ROCKY TOP RESOURCES, INC. Rezone Submittal

01-09-18

PROPERTY DESCRIPTION: 1755 E. Las Vegas Street

REZONE MAP: RR-0.5 RESIDENTIAL
TO I-3 HEAVY INDUSTRIAL ZONE

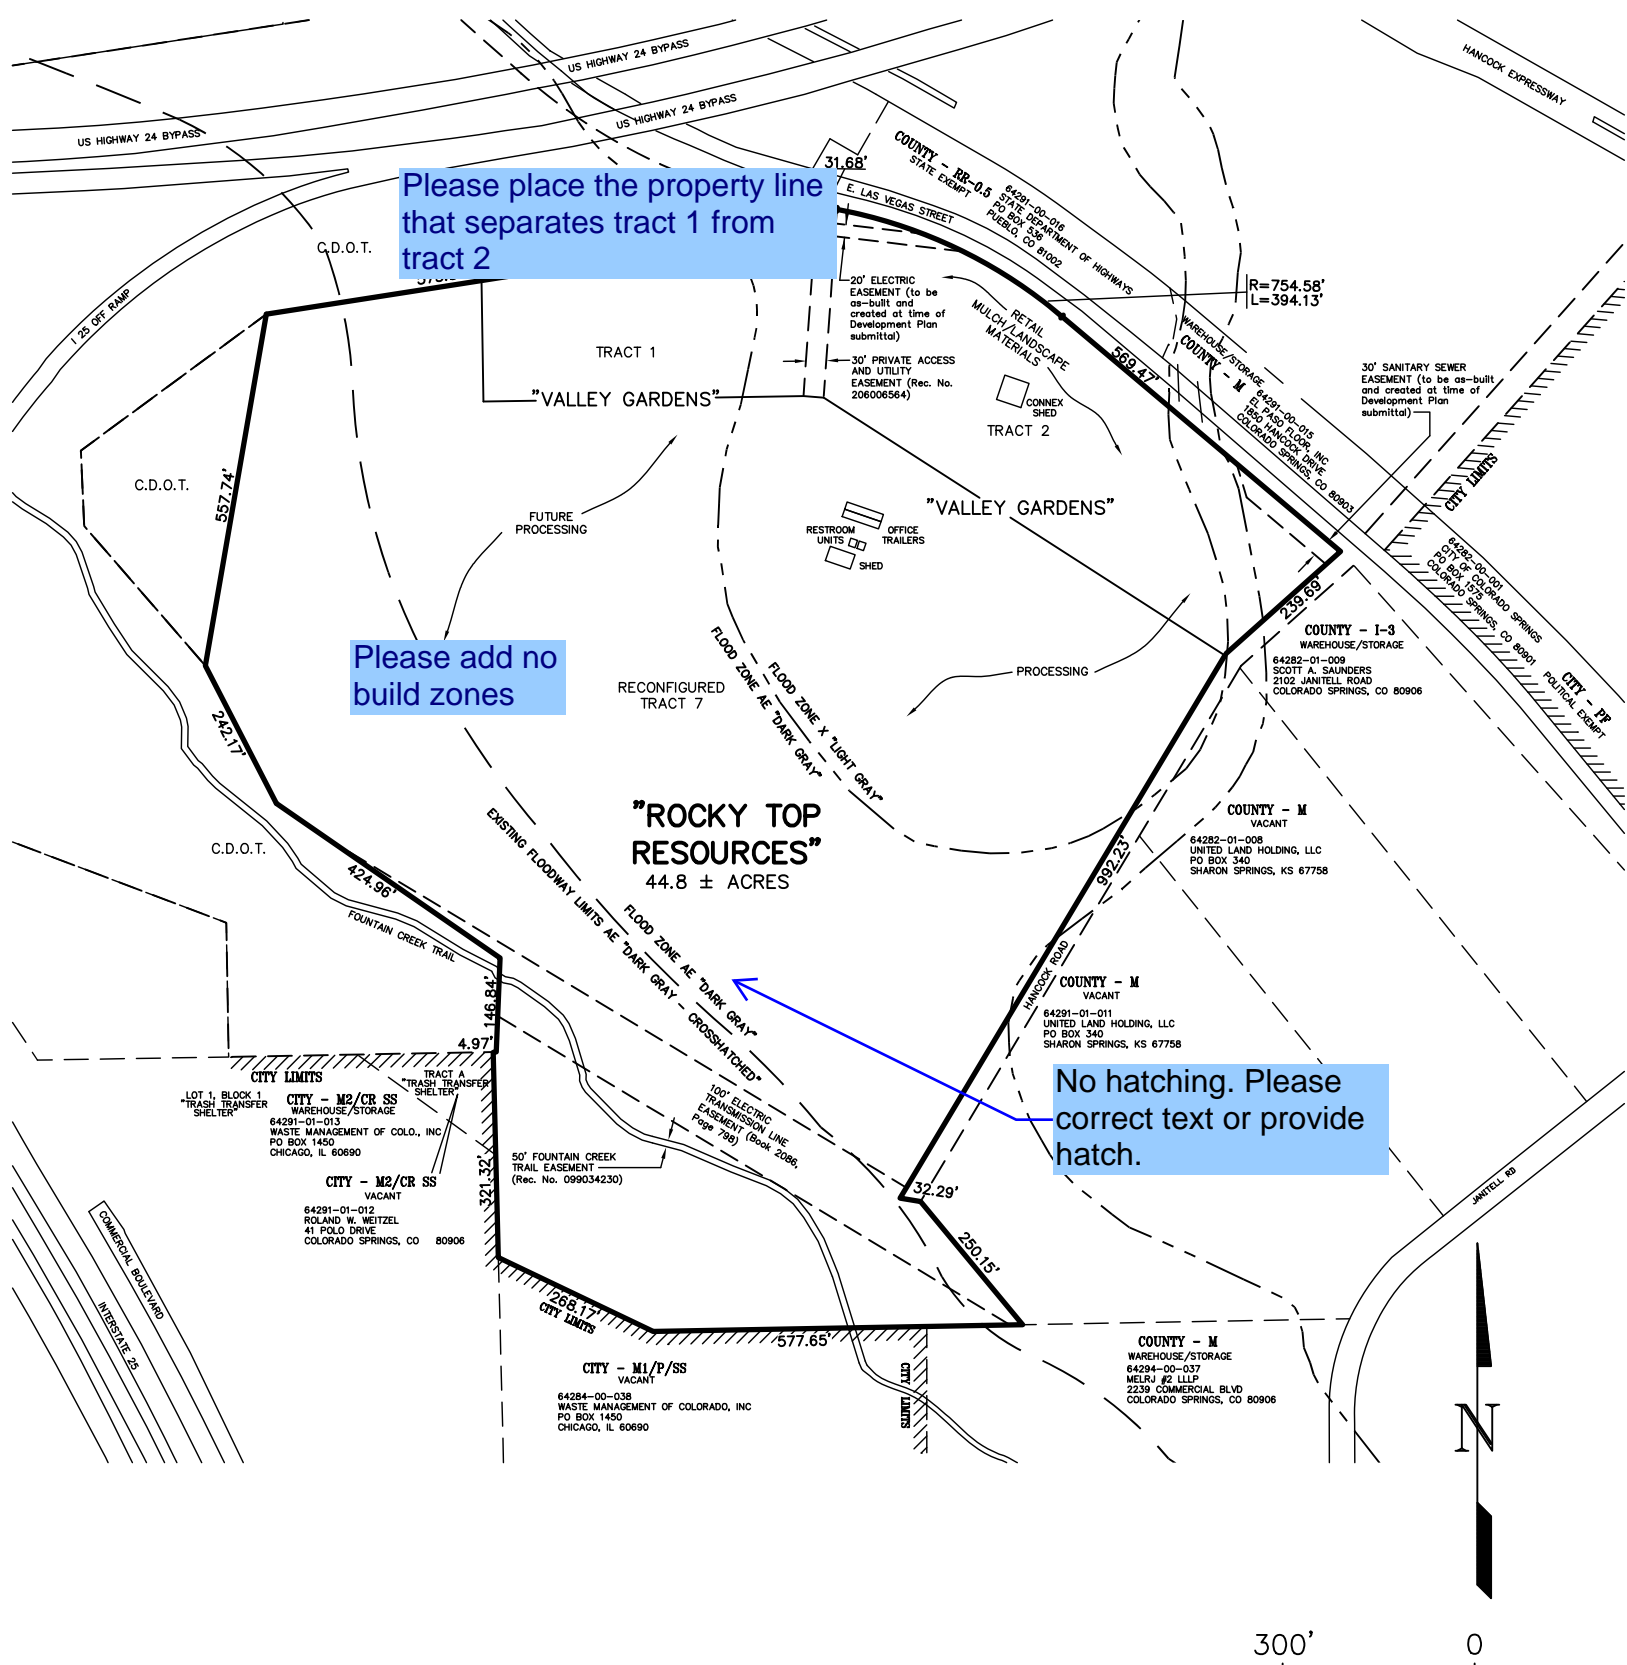
Legal Description is missing information from
number 3 on the Title Commitment for the Road
that was vacated per resolution 206179579.
Legal needs to match Title Commitment Legal
